DEVELOPMENT FACILITATIVE TEAM (DFT)
HEARING OCTOBER 2, 2024
UPDATE: 06/05/2024 Application Submittal

Project Number PR-2024-010446
SI-2024-00774-SITE PLAN DFT

RE: Site Plan Amendment for new construction

APPLICANT RESPONSES TO THE STAFF COMMENTS:

Drawing file: 2-24-2025 / AC1-SITE DEVELOPMENT PLAN.pdf

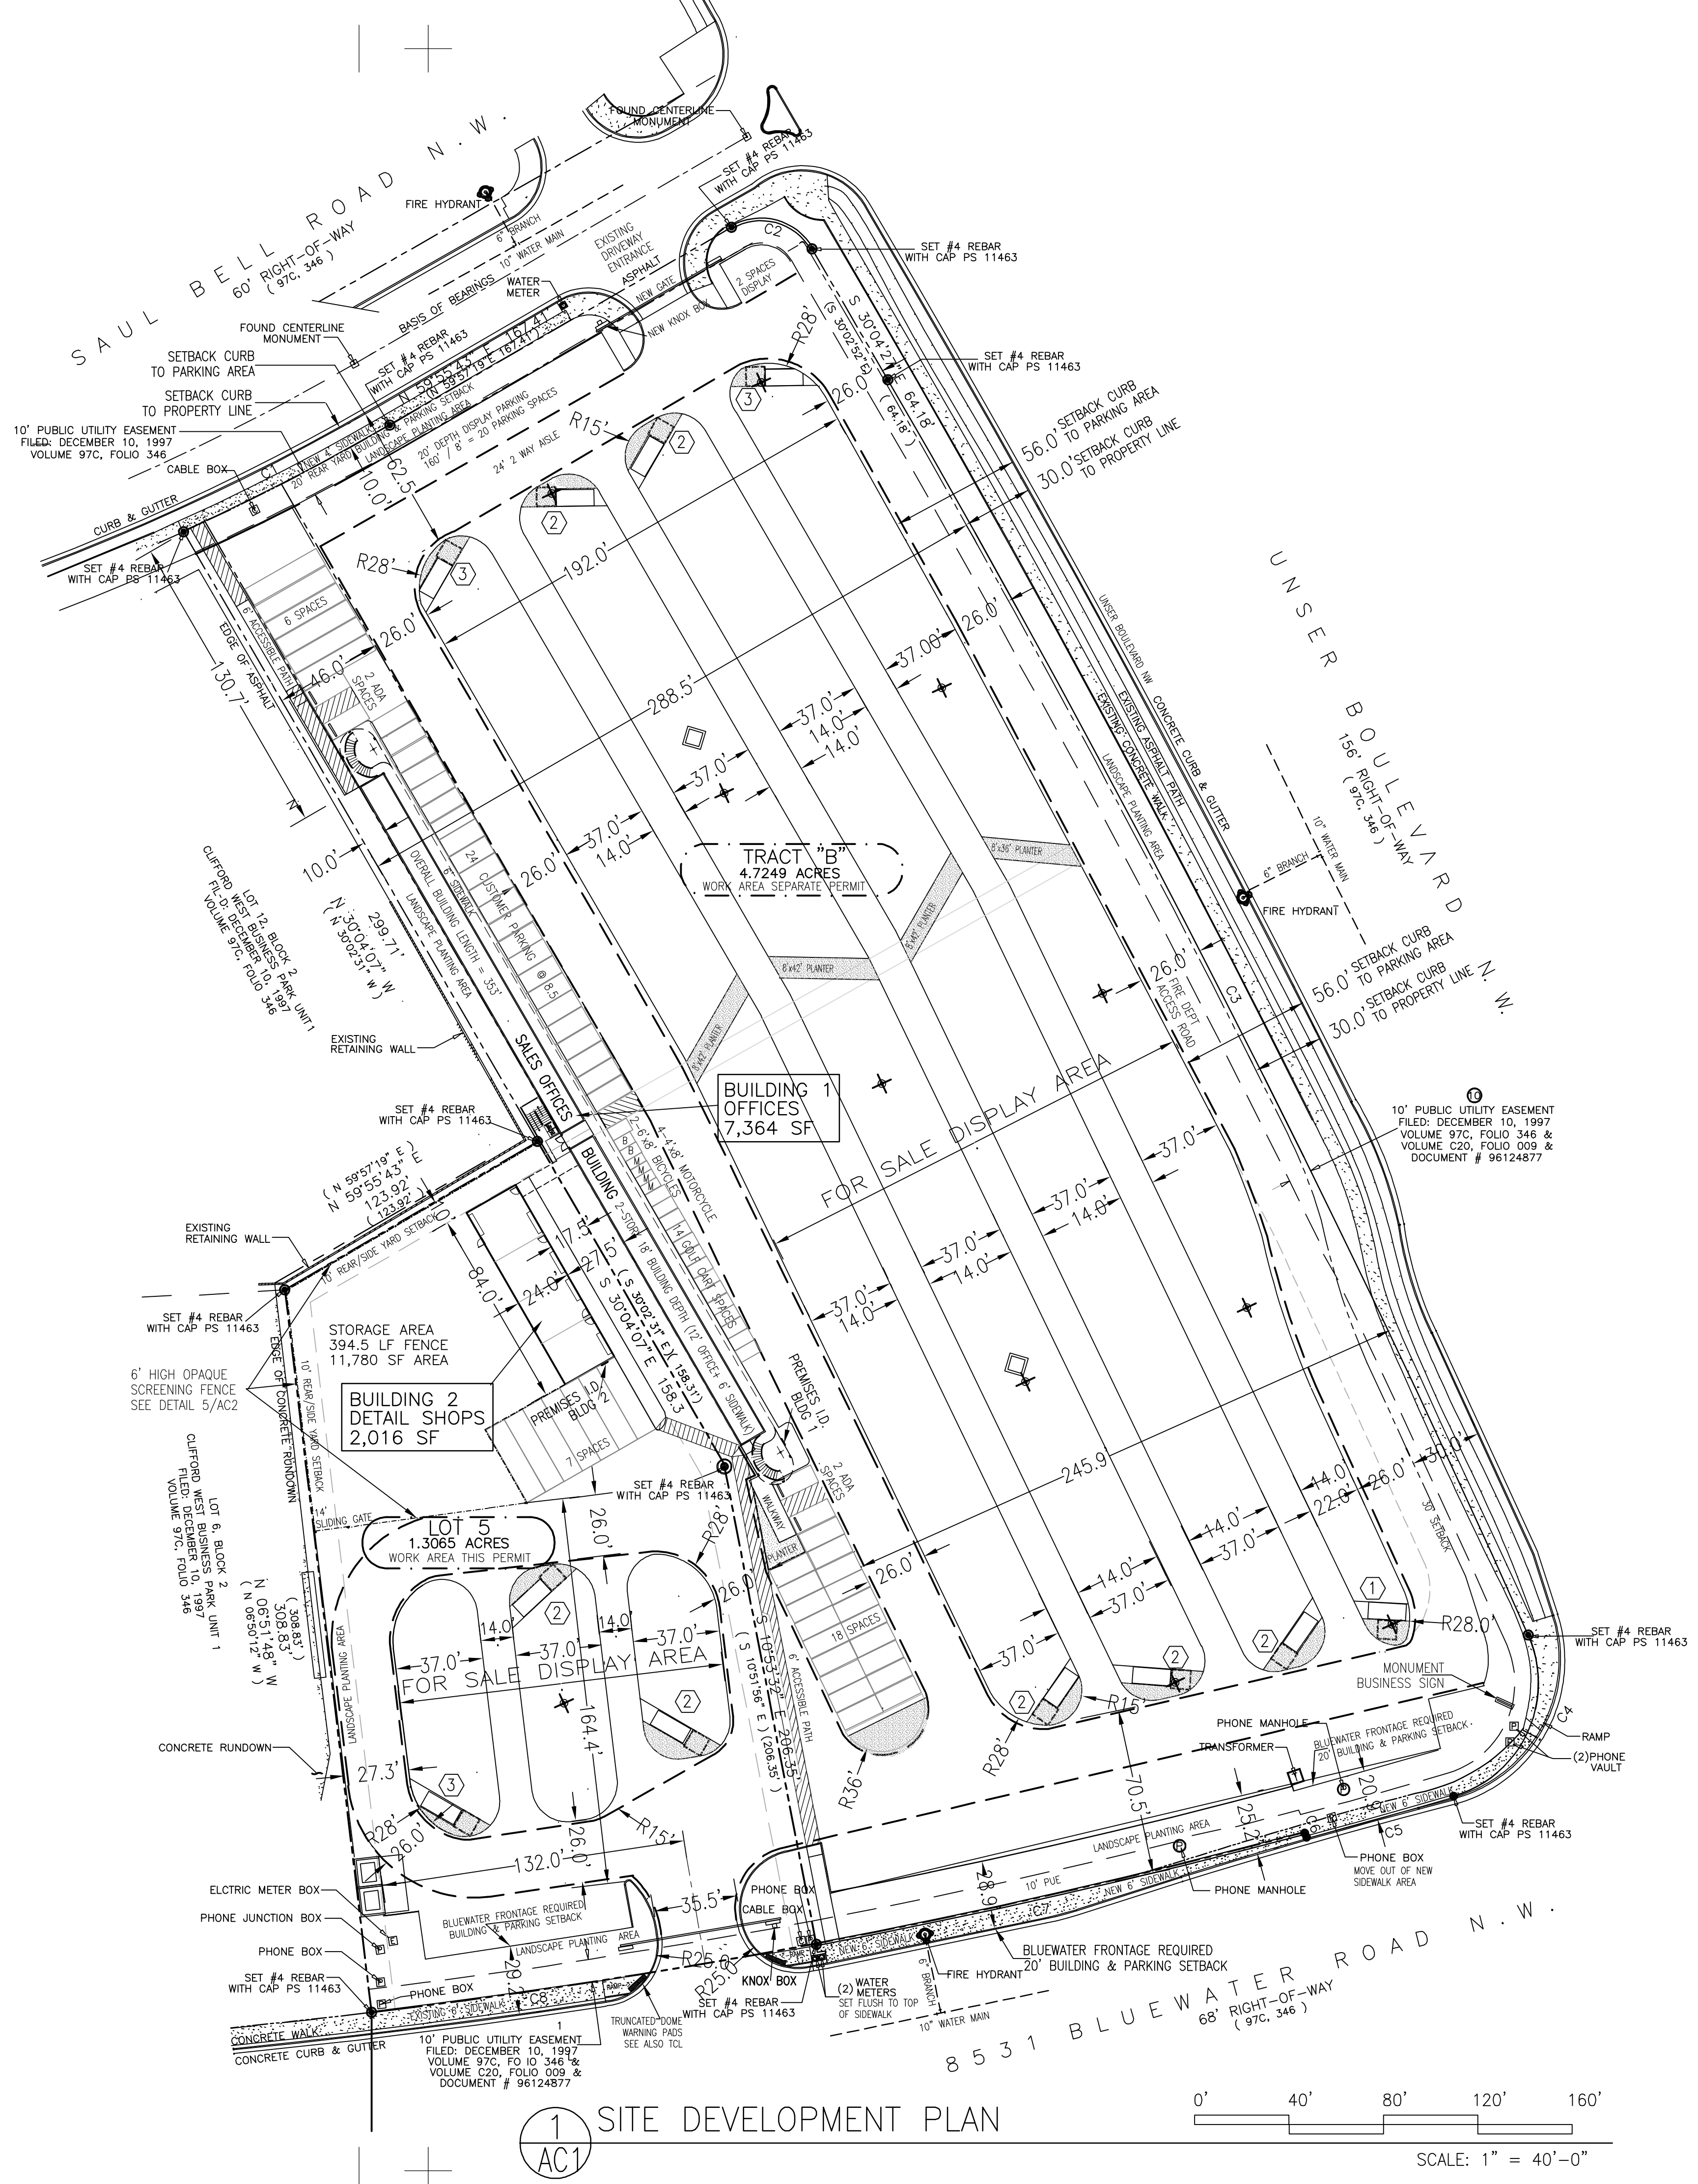
- Clarify and confirm that all development, landscaping, and screening are on private property and they do not encroach into the public right of way, except for the street landscape buffer.

See drawing AC1 Site Plan and new Landscape Plan
- Confirm that the proposed metal fencing is meeting the material requirements of the Clifford West Plan. Walls and fences will require separate permitting through Code Enforcement and/or Building Safety. Wall/fence location and height may require additional approvals, such as a ZHE variance. *Verification per Code Enforcement and section 7 of the IDO.
